WEST SUSSEX COUNTY COUNCIL CONSULTATION

TO:	Arun District Council FAO: Amber Willard
FROM:	WSSC - Highways Authority
DATE:	4 August 2020
LOCATION:	34 Sudley Road Bognor Regis PO21 1ER
SUBJECT:	BR/162/20/PD Notification of prior approval under Schedule 2, Part 3, Class O for the change of use of 3 storey office (B1(a)) to 3 No flats (C3 Dwelling houses).
DATE OF SITE VISIT:	n/a
RECOMMENDATION:	Advice
S106 CONTRIBUTION TOTAL:	n/a

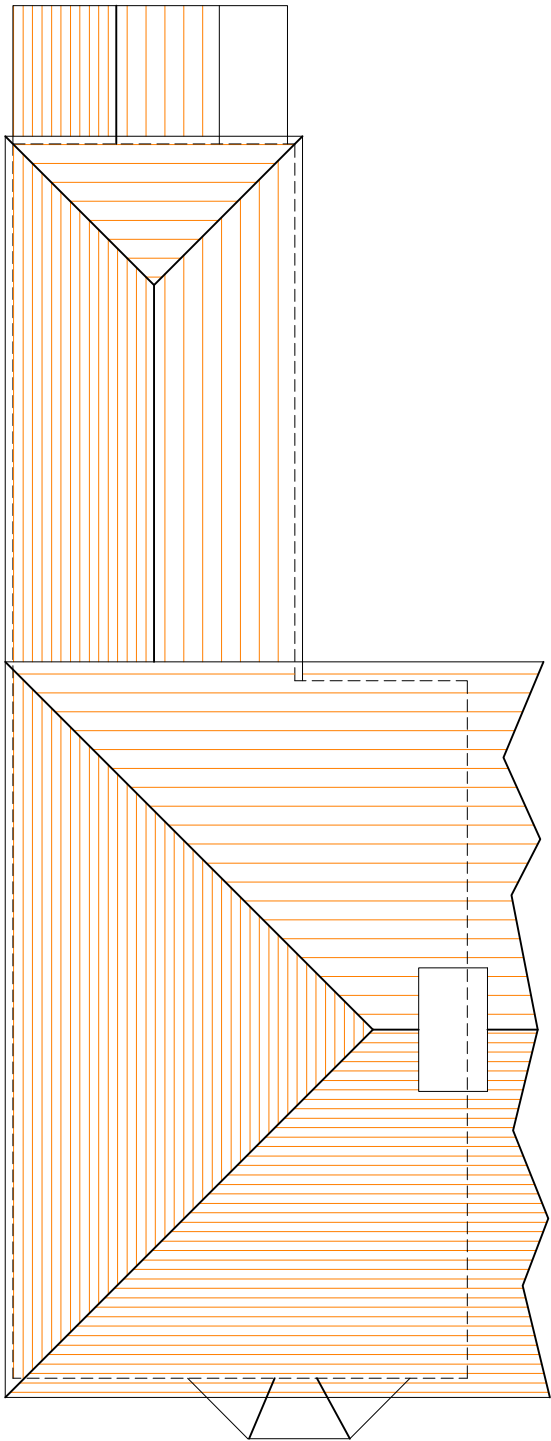
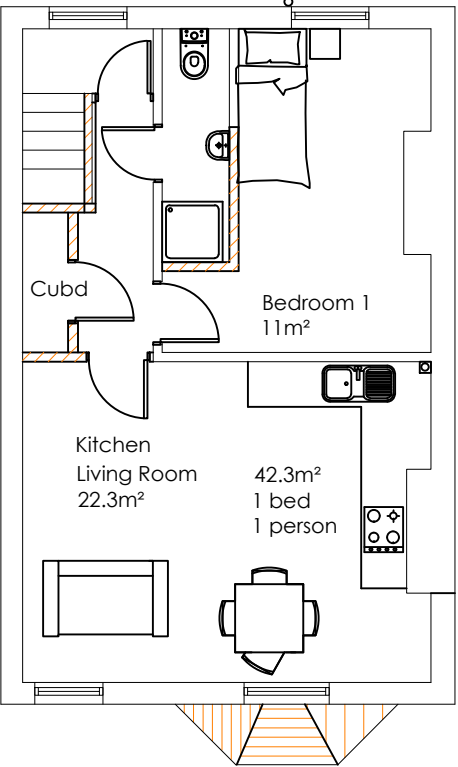
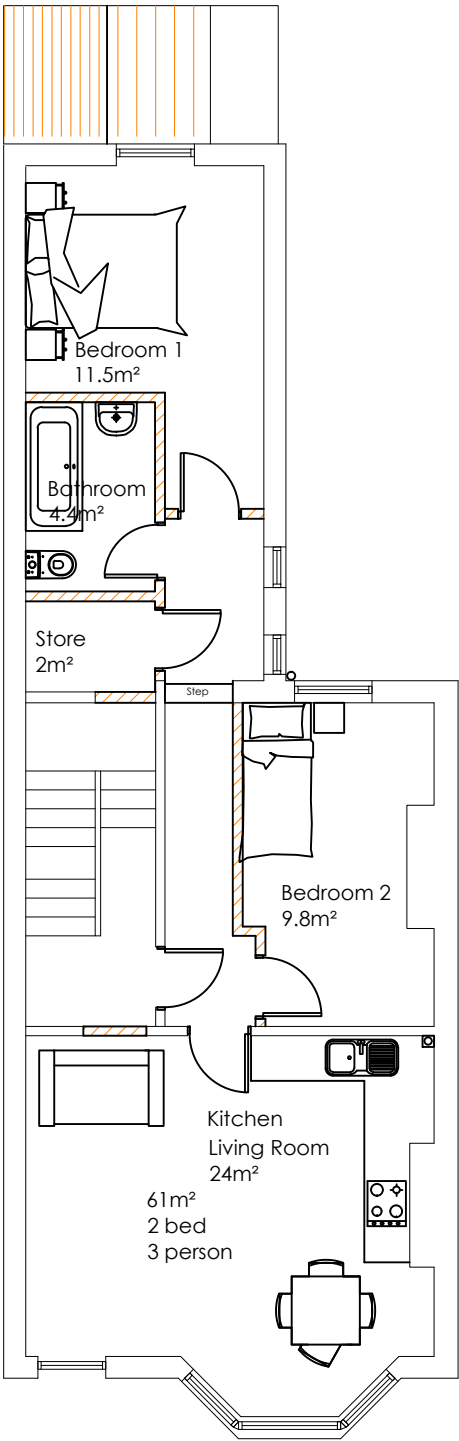
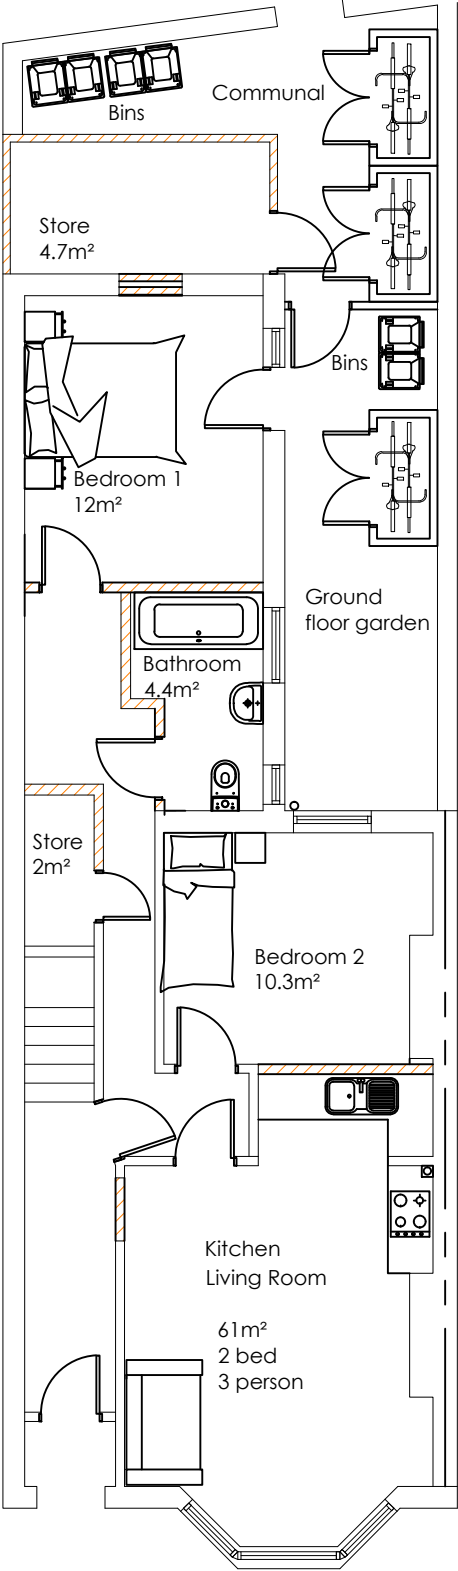
Independent secure and covered cycle parking facilities have been demonstrated on the propose plans.
